Application for a Non-Material Amendment Following a Grant of Planning Permission

Erection of single storey rear extension, new front porch and conversion of existing garage into office and workshop with external alterations.  
Erection of garage.

23/50297/FULL

Gable to West elevation of garage extension, rather than the hip currently shown on the approved drawings

Drawing Title
Proposed Floor Plans and Elevations

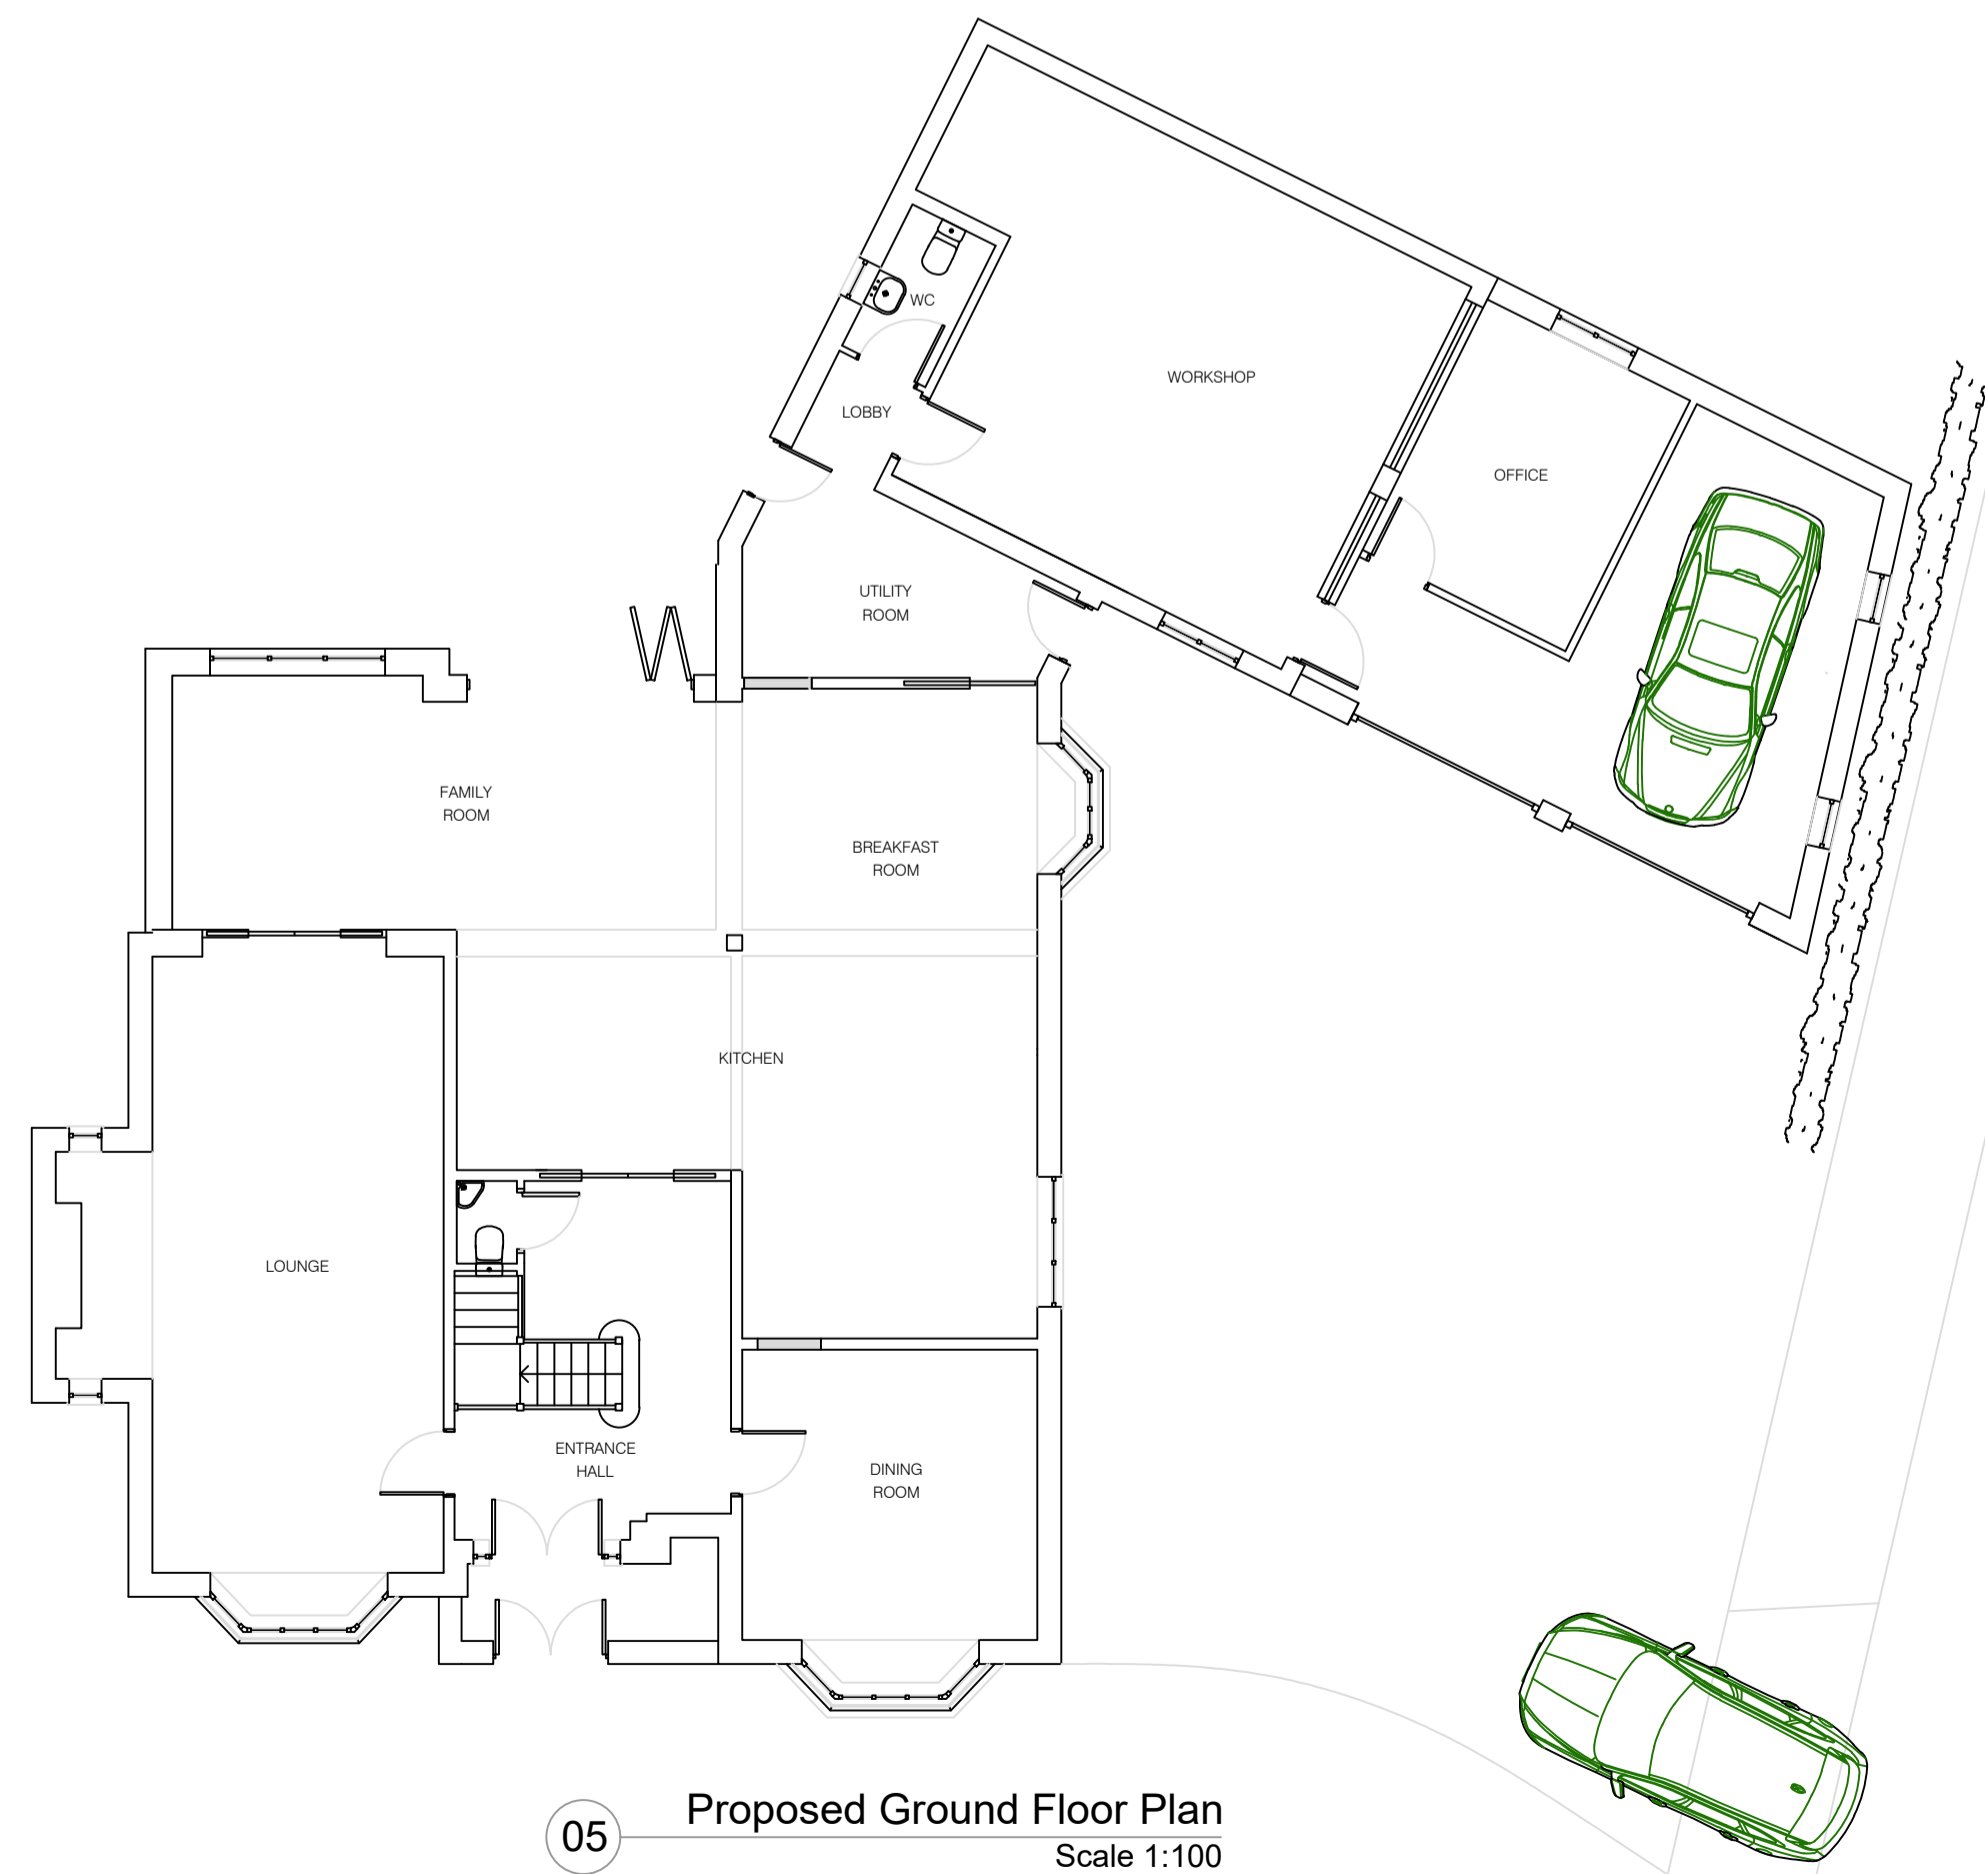
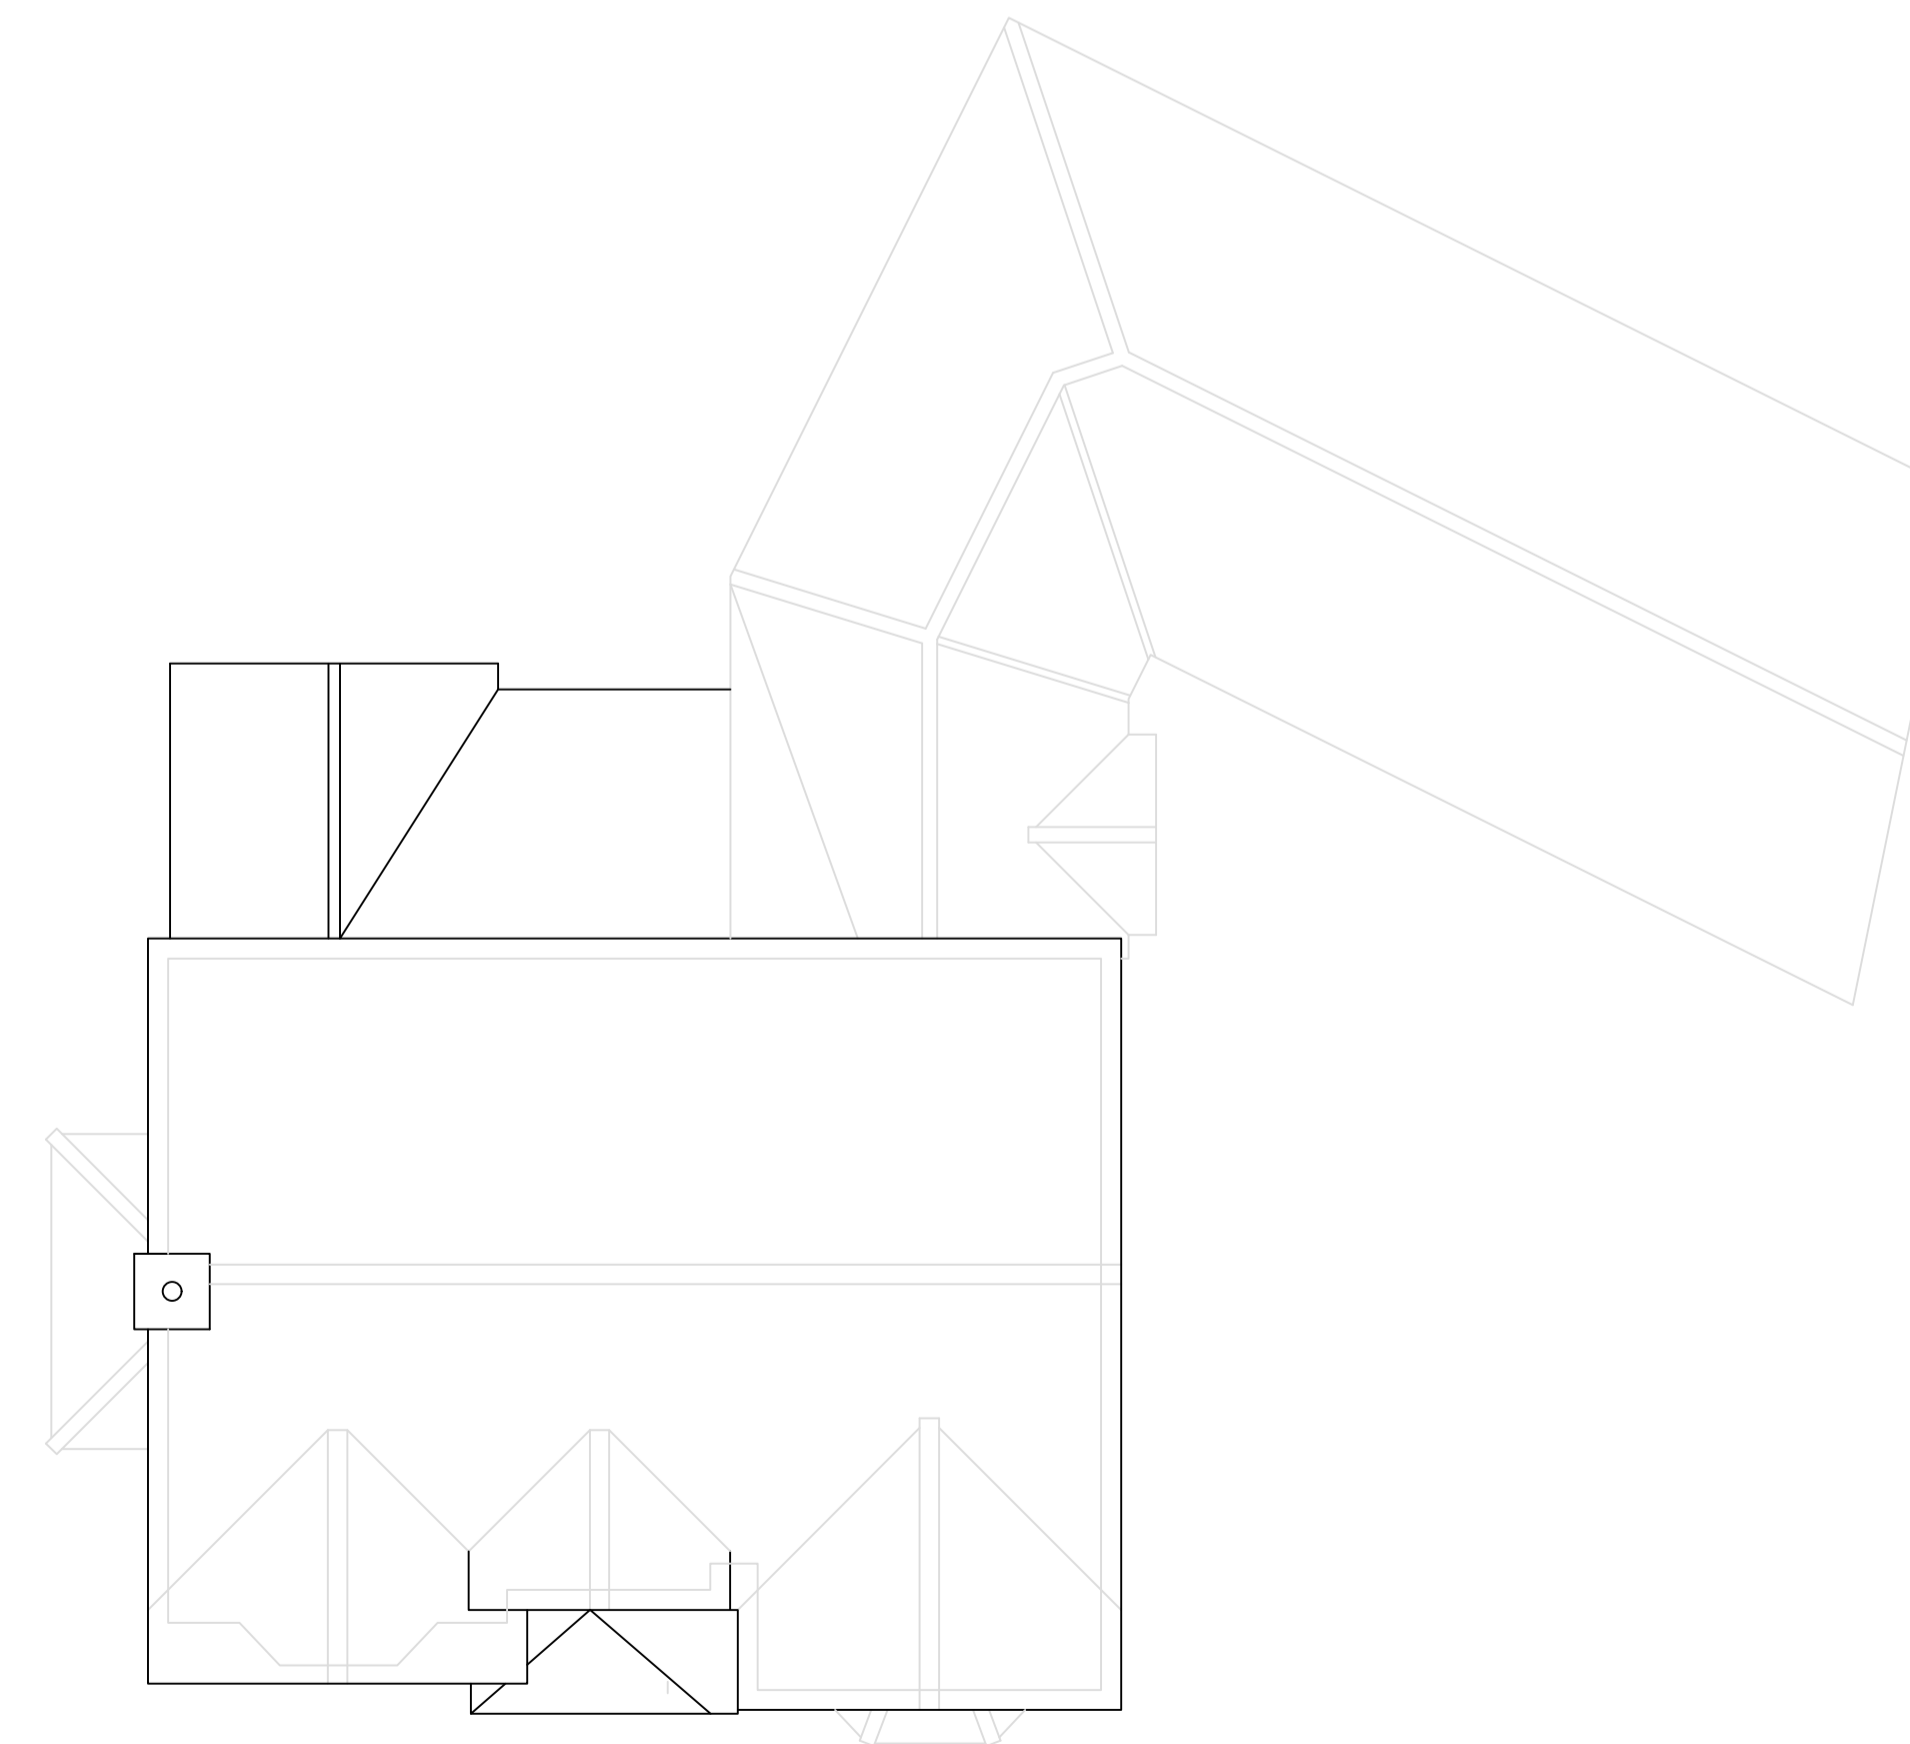
Appearance - this will match the existing and we can carry over the existing tile hanging detail to the new gable elevation
